**WEST SUSSEX COUNTY COUNCIL
COUNTY HIGHWAYS CONSULTATION RESPONSE**

DATE: 6 March 2018

**SUBJECT: FG/27/18/PL - Demolition of care home & redevelopment to provide for
apartment building for 7 self-contained flats, cycle parking, bin storage & car parking.**

58, Ferringham Lane, Ferring, BN12 5LU

Proposed Access Visibility Splay Plan

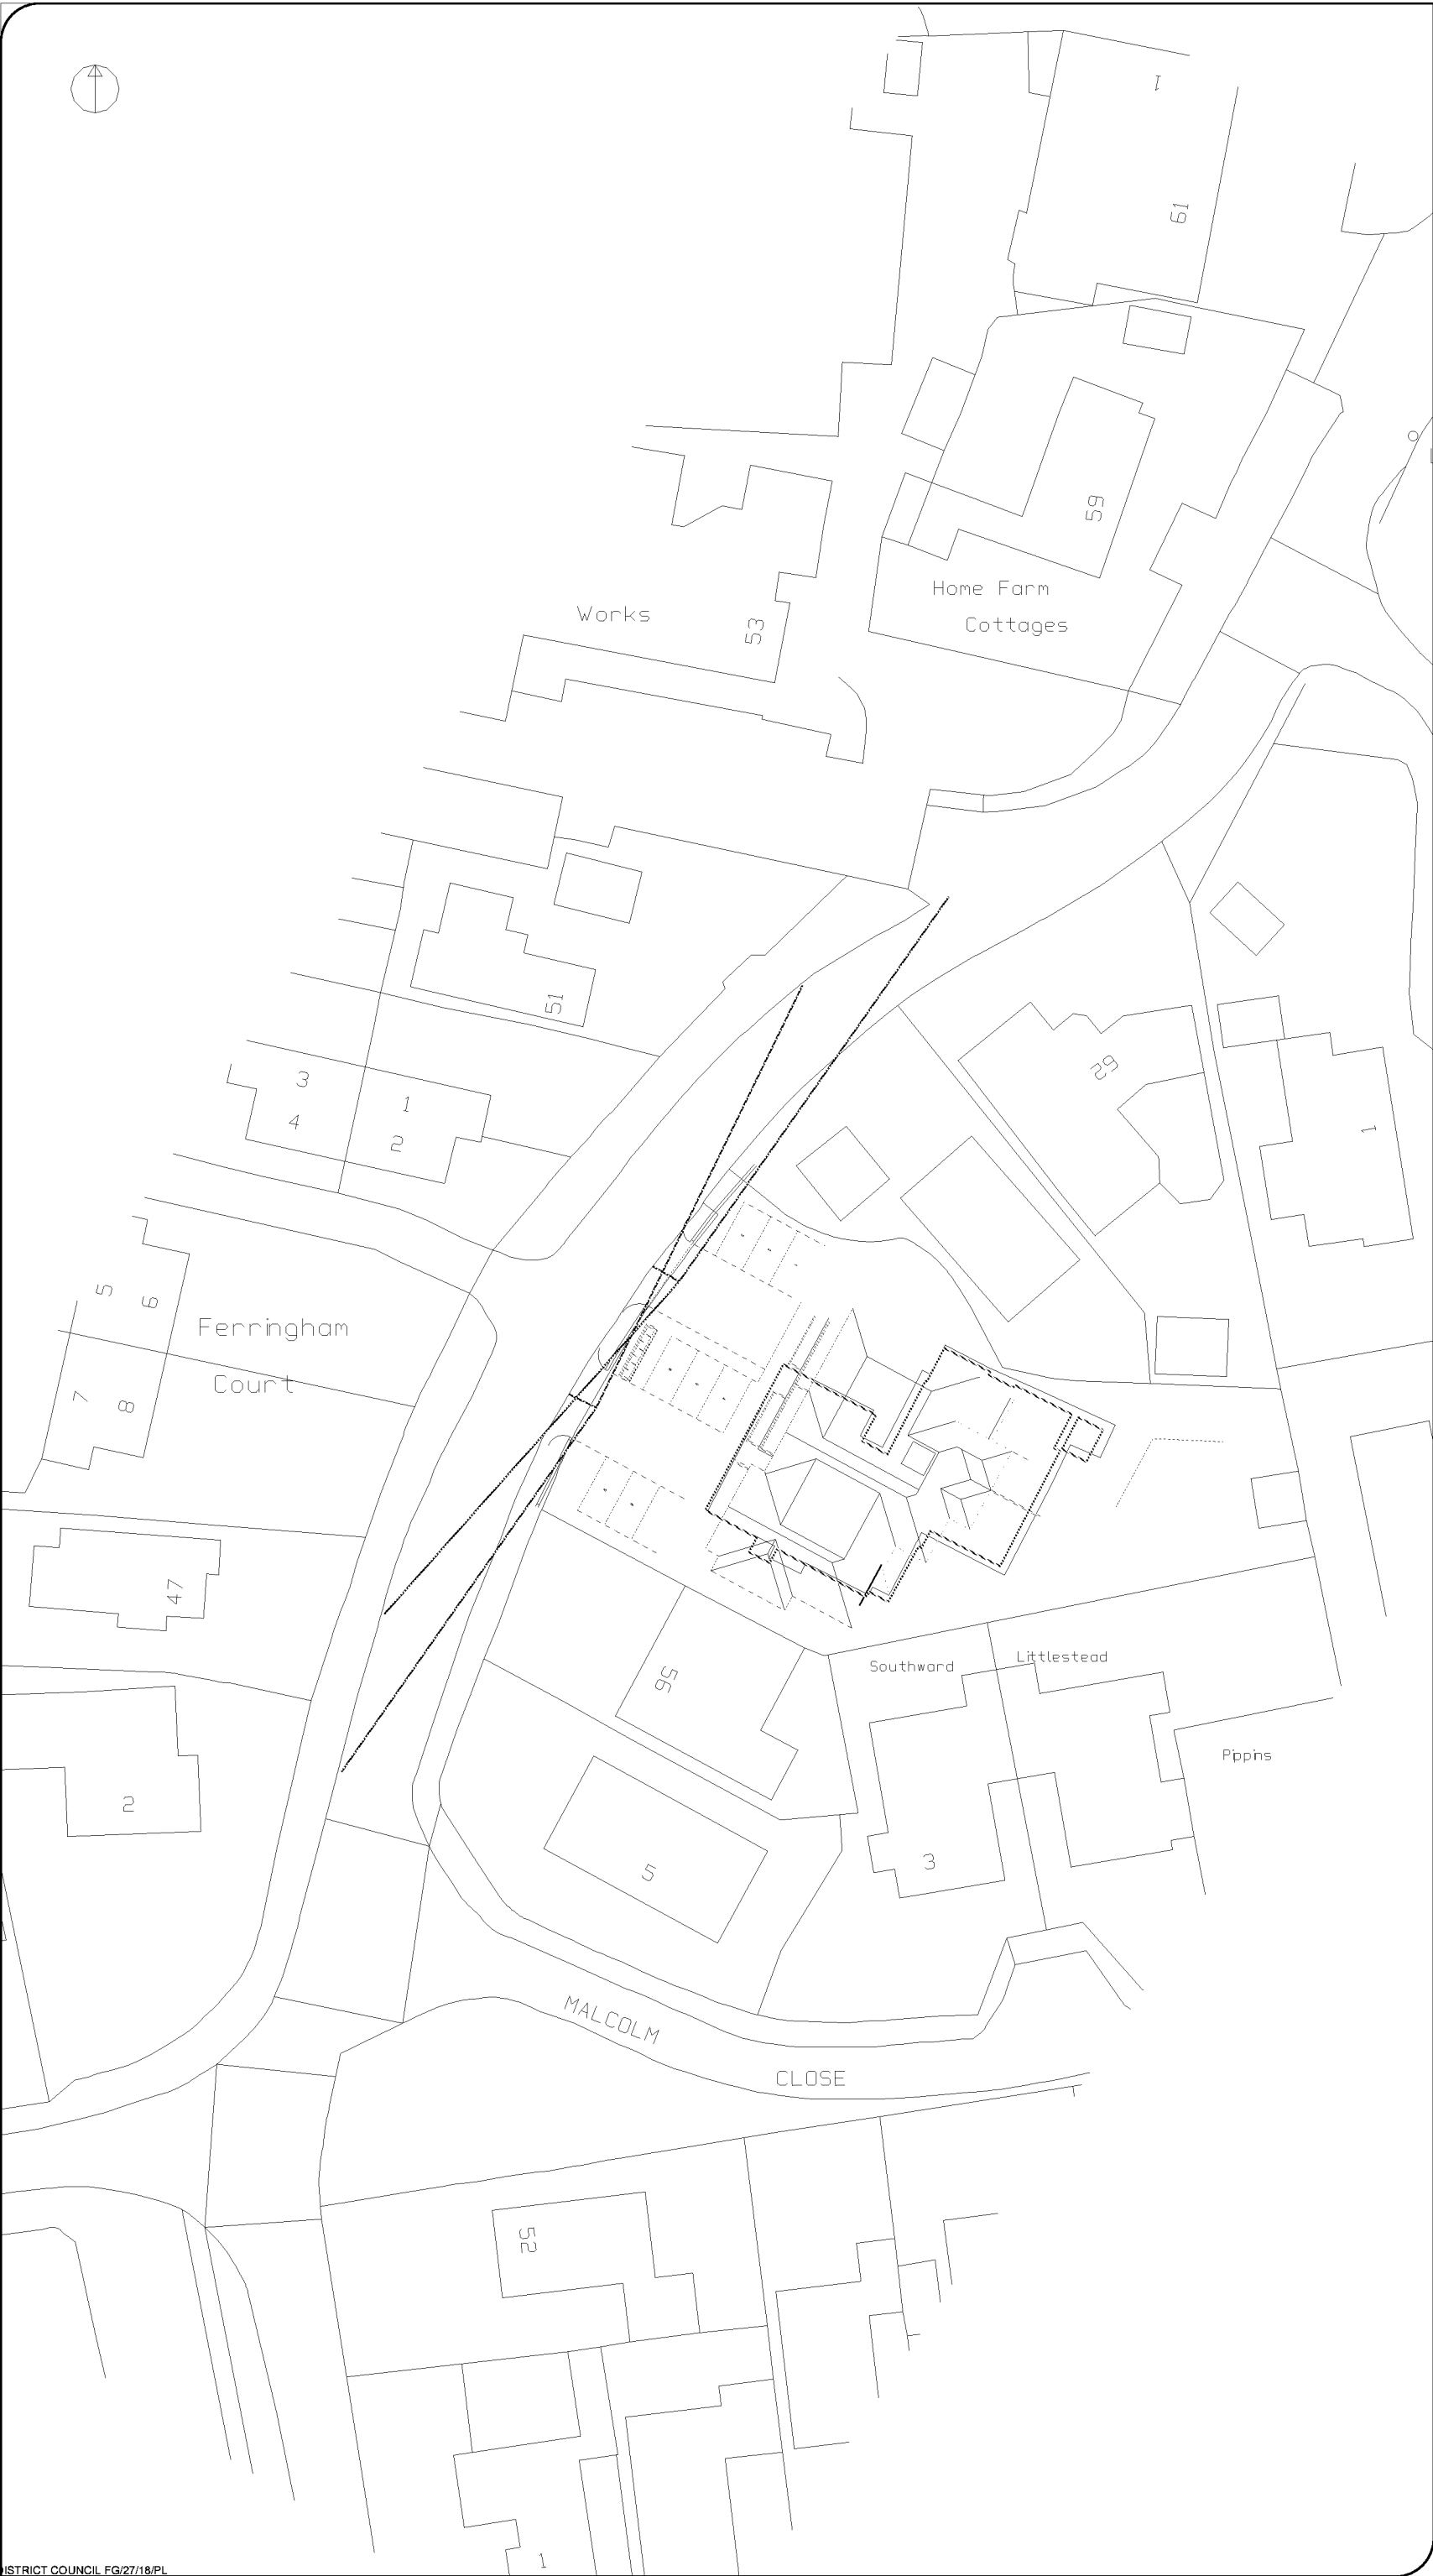
The current access has not been maintained and is formed of differing materials. There are no kerb-lines along this section of Ferringham Lane, however some formalisation and standard construction of the proposed access points would be recommended.

As the road is private there is no legal/enforceable speed restriction in place however, given the location it is unlikely speeds will exceed 30mph. It is therefore recommended that visibility splays are provided in line with Manual for Streets 2.
